DEVELOPMENT HEARING OFFICER Code Enforcement Comments

PR-2021-005717

PROJECT NAME:

Project Name: Volcano Mesa at the Trails

1 TYPICAL 32' STREET SECTION STA 20+35.08 TO 23+43.61 SIDREAU LOOP AND ATHERSTONE LANE
NOT TO SCALE

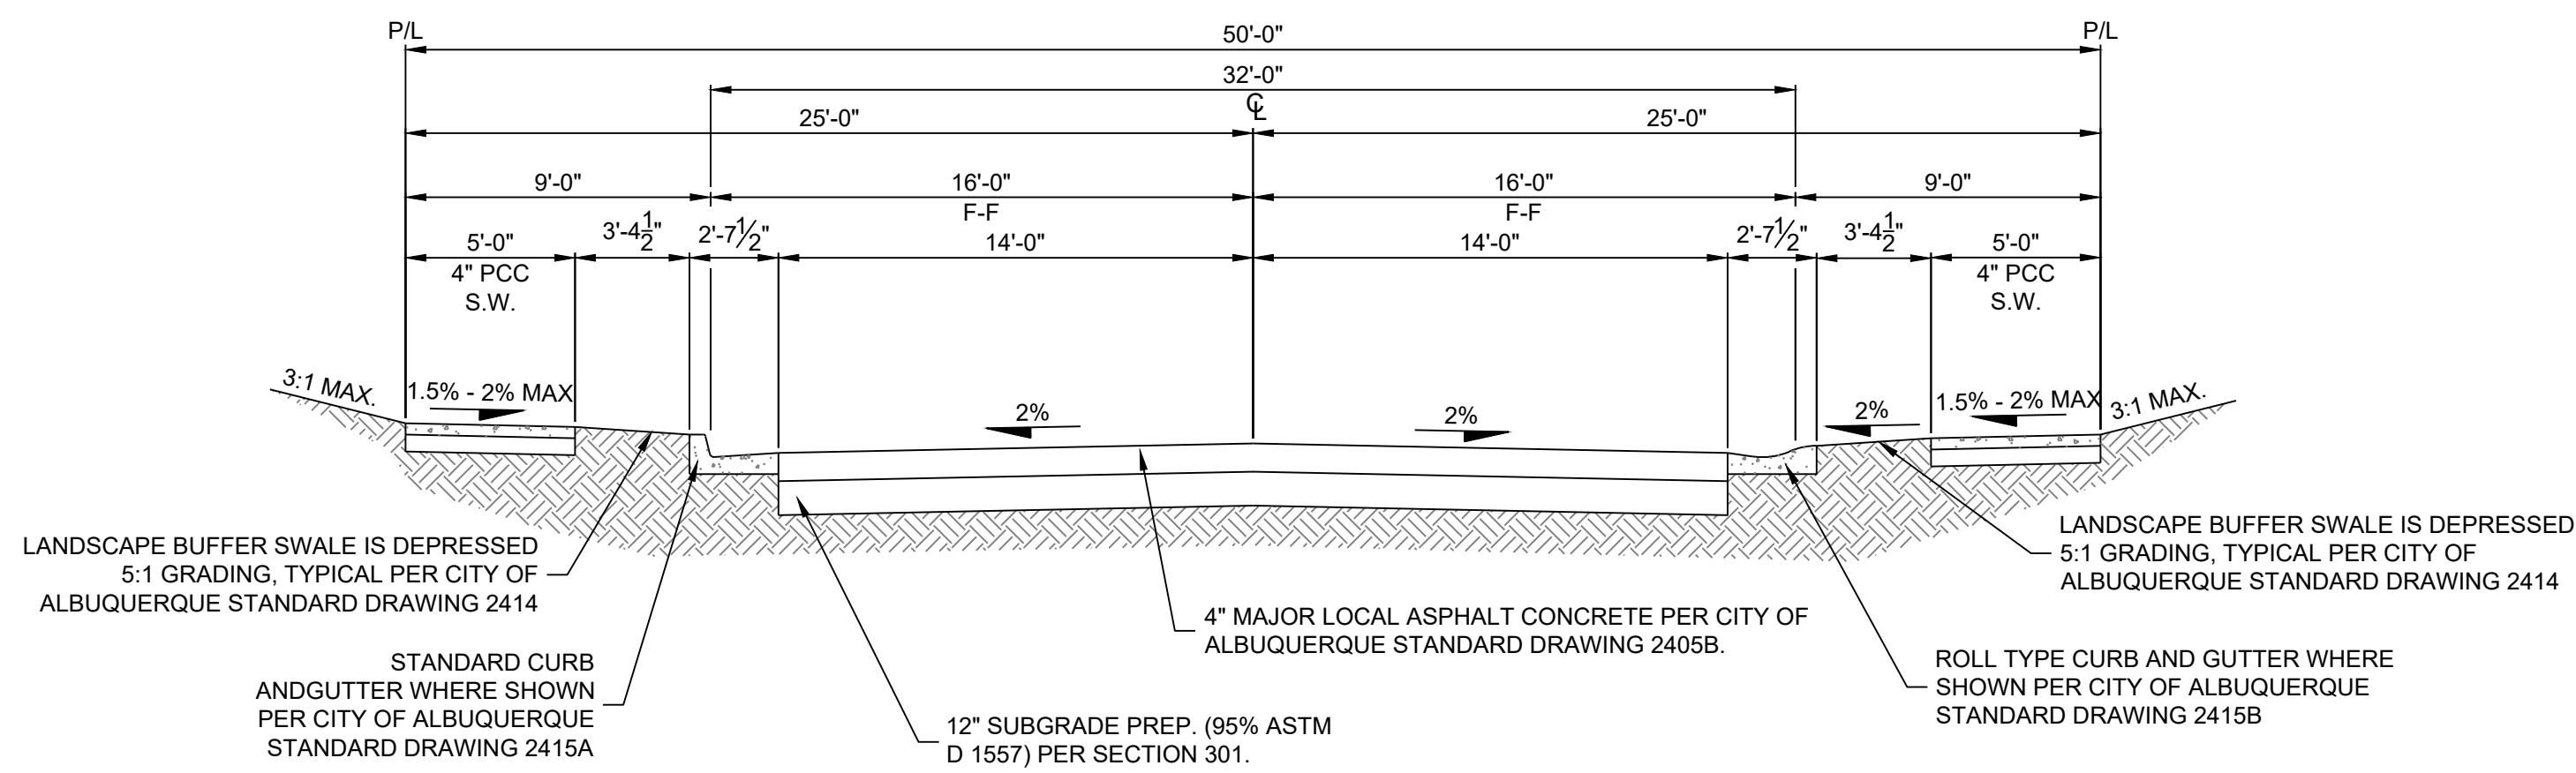
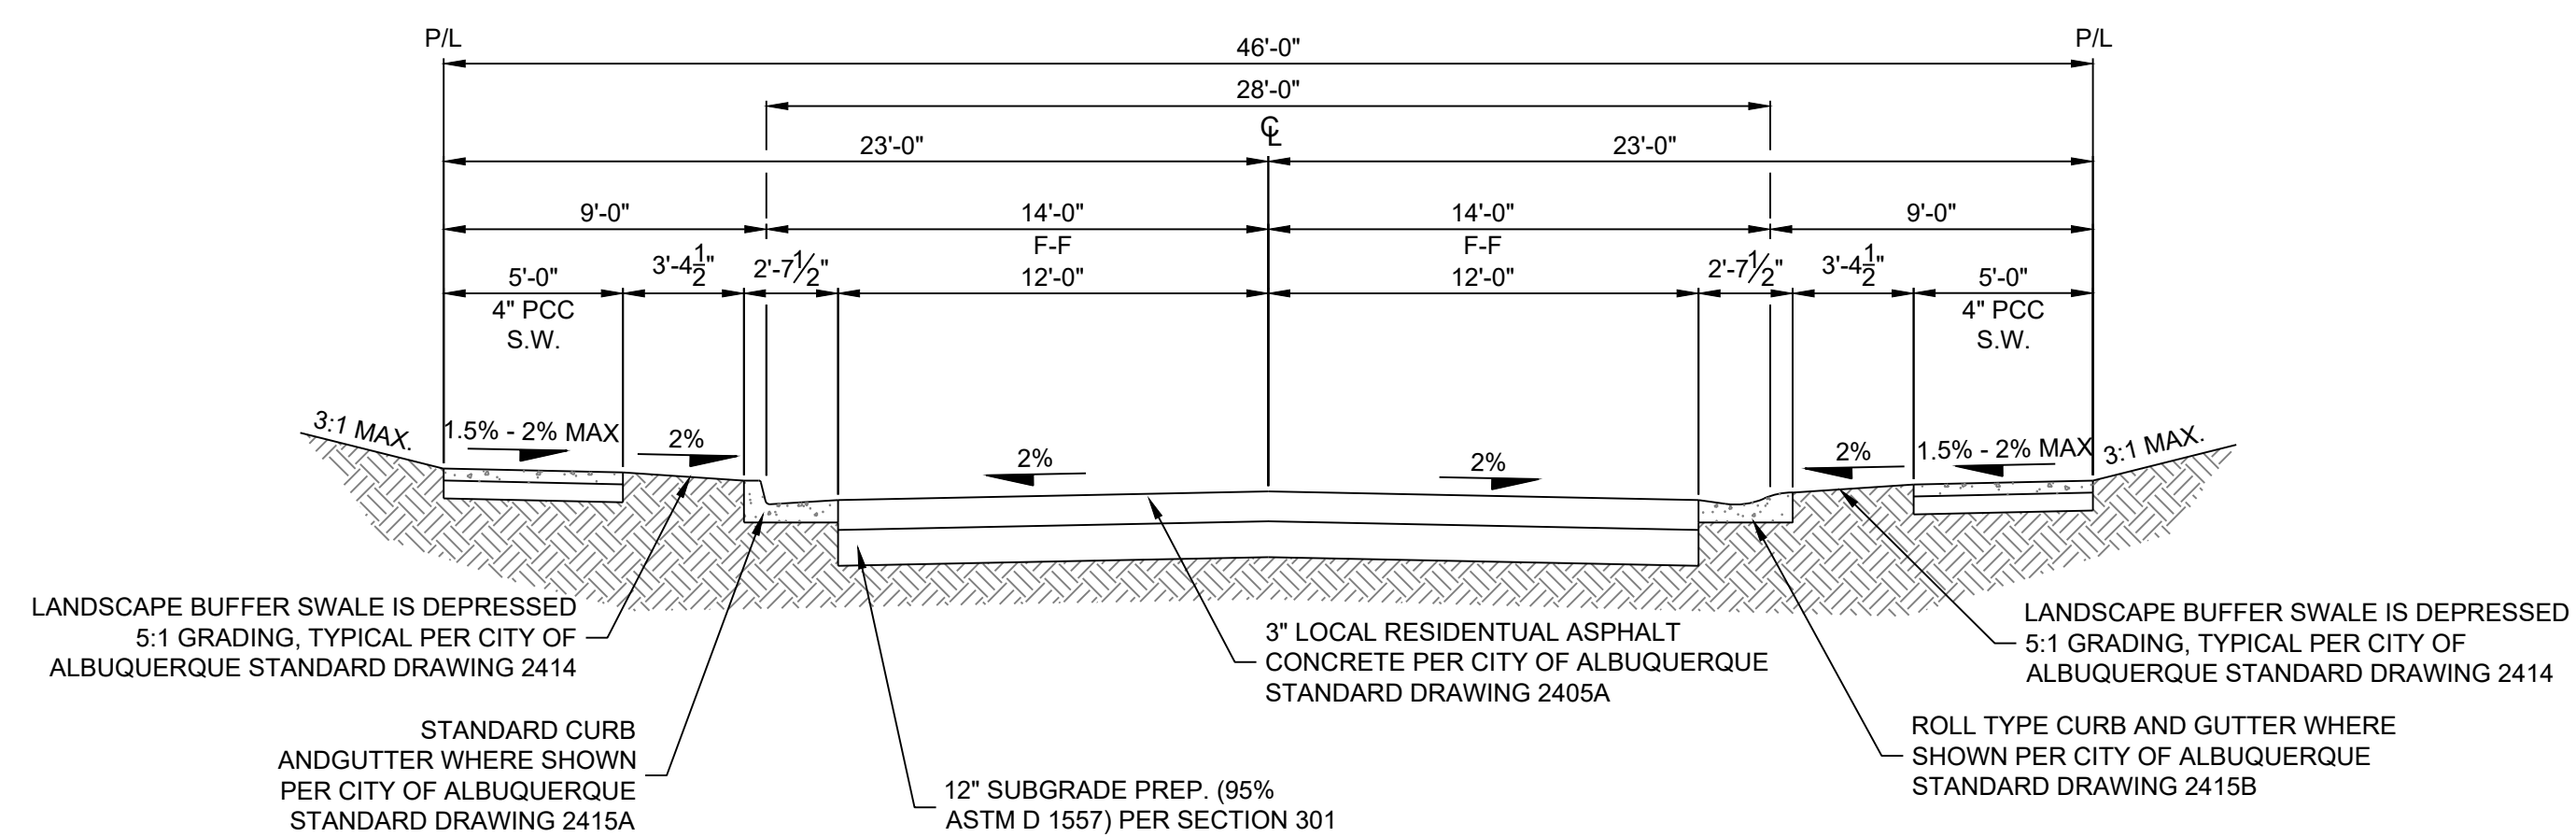
1. Landscape buffers along internal streets are narrower than the 4' minimum called for in the DPM. Transportation defers to Parks and Rec and Planning as to whether this is acceptable.
2. All other comments have been addressed. No objection.
